19 November 2020

SF2017/249332; WST17/00173/05

**SSD 8847: Lots 137, 140 and 80 DP 754309 & Lots 1 & 2 DP 854326; Allweather Road, Dunedoo
Environmental Impact Statement (EIS) - Dunedoo Solar Farm**

Appendix A – Castlereagh Highway / Allweather Road Intersection Design

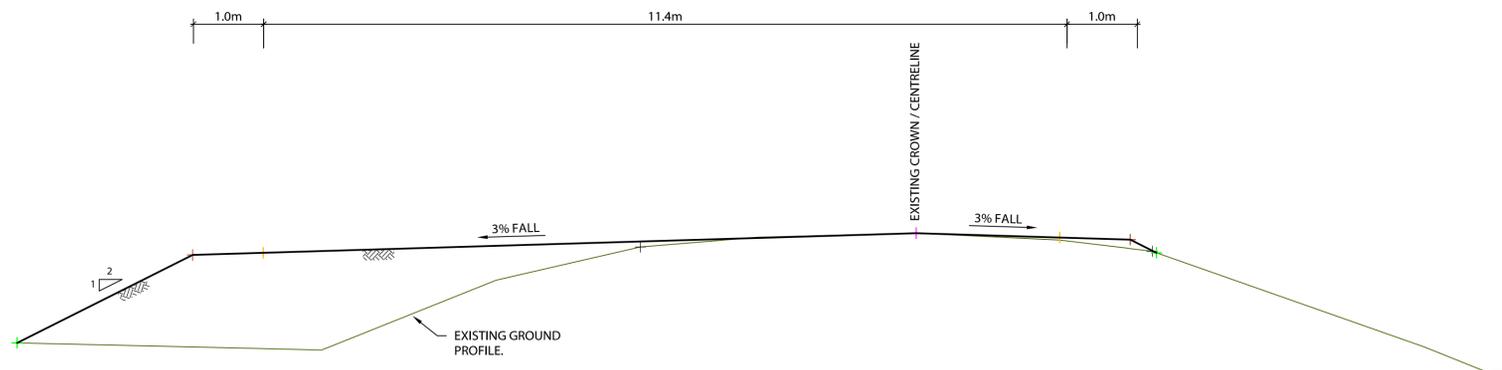
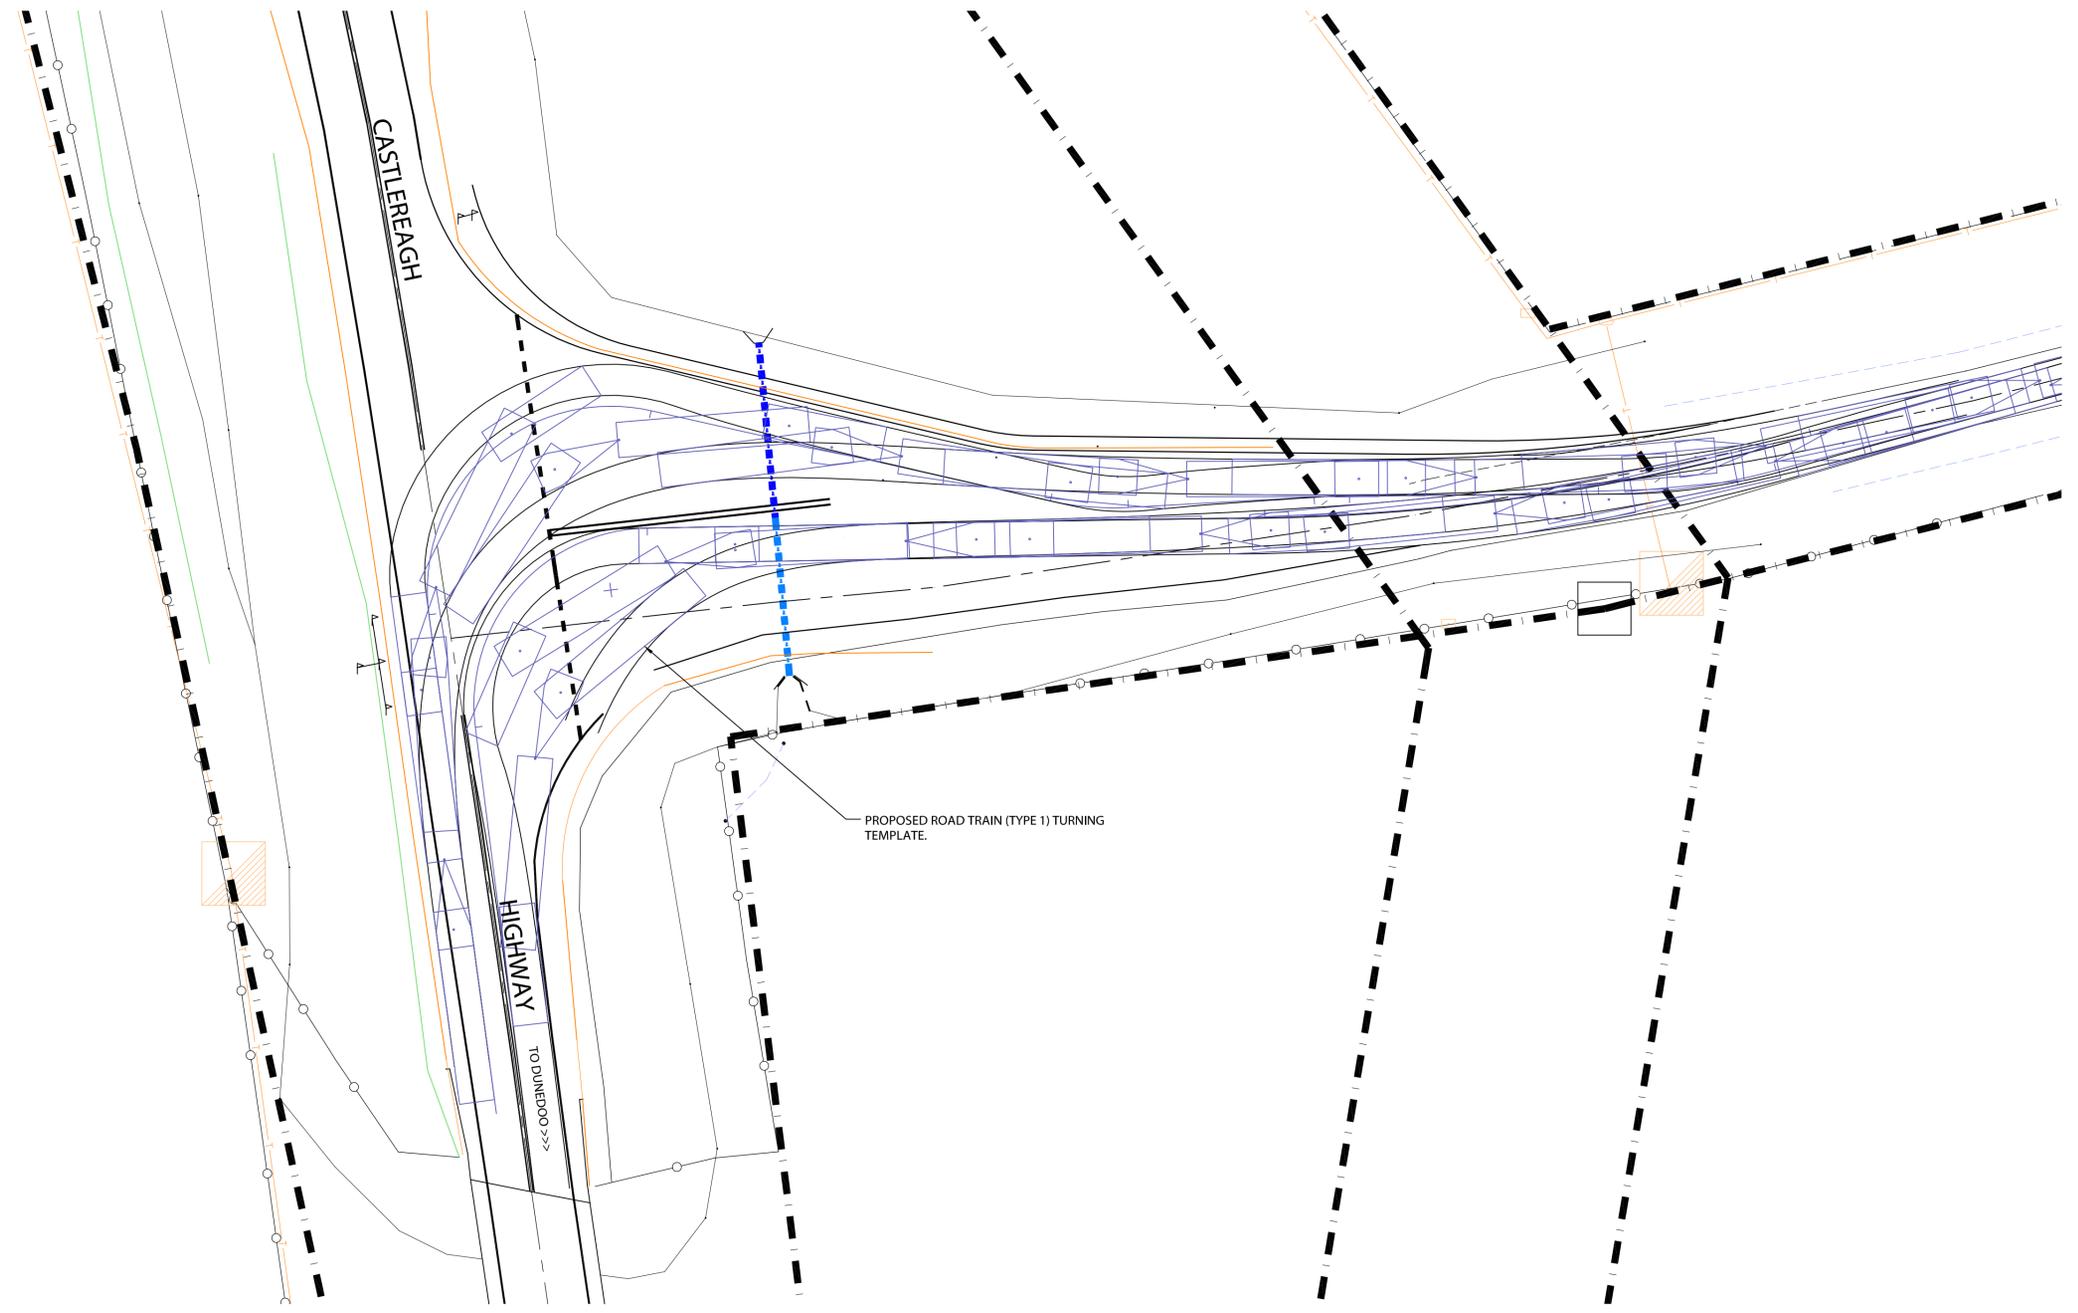
The TIA prepared by Stantec proposes an alternative treatment of widening the shoulder in the north eastern corner of the intersection of Allweather Road. This proposed alternative treatment will not alleviate the inherent safety risk of heavy vehicles accessing Allweather Road from the Castlereagh Highway as part of this proposal. Through traffic will not be able to safely pass heavy vehicles turning right into Allweather Road or turning left from Allweather Road onto the Castlereagh Highway, increasing the risk of rear end collisions with through traffic.

Based on the above analysis TfNSW cannot concur, pursuant to *s138(2) of the Roads Act 1993*, to the use by vehicles required to access the site as part of this proposal via the intersection of the Castlereagh Highway and Allweather Road, as proposed.
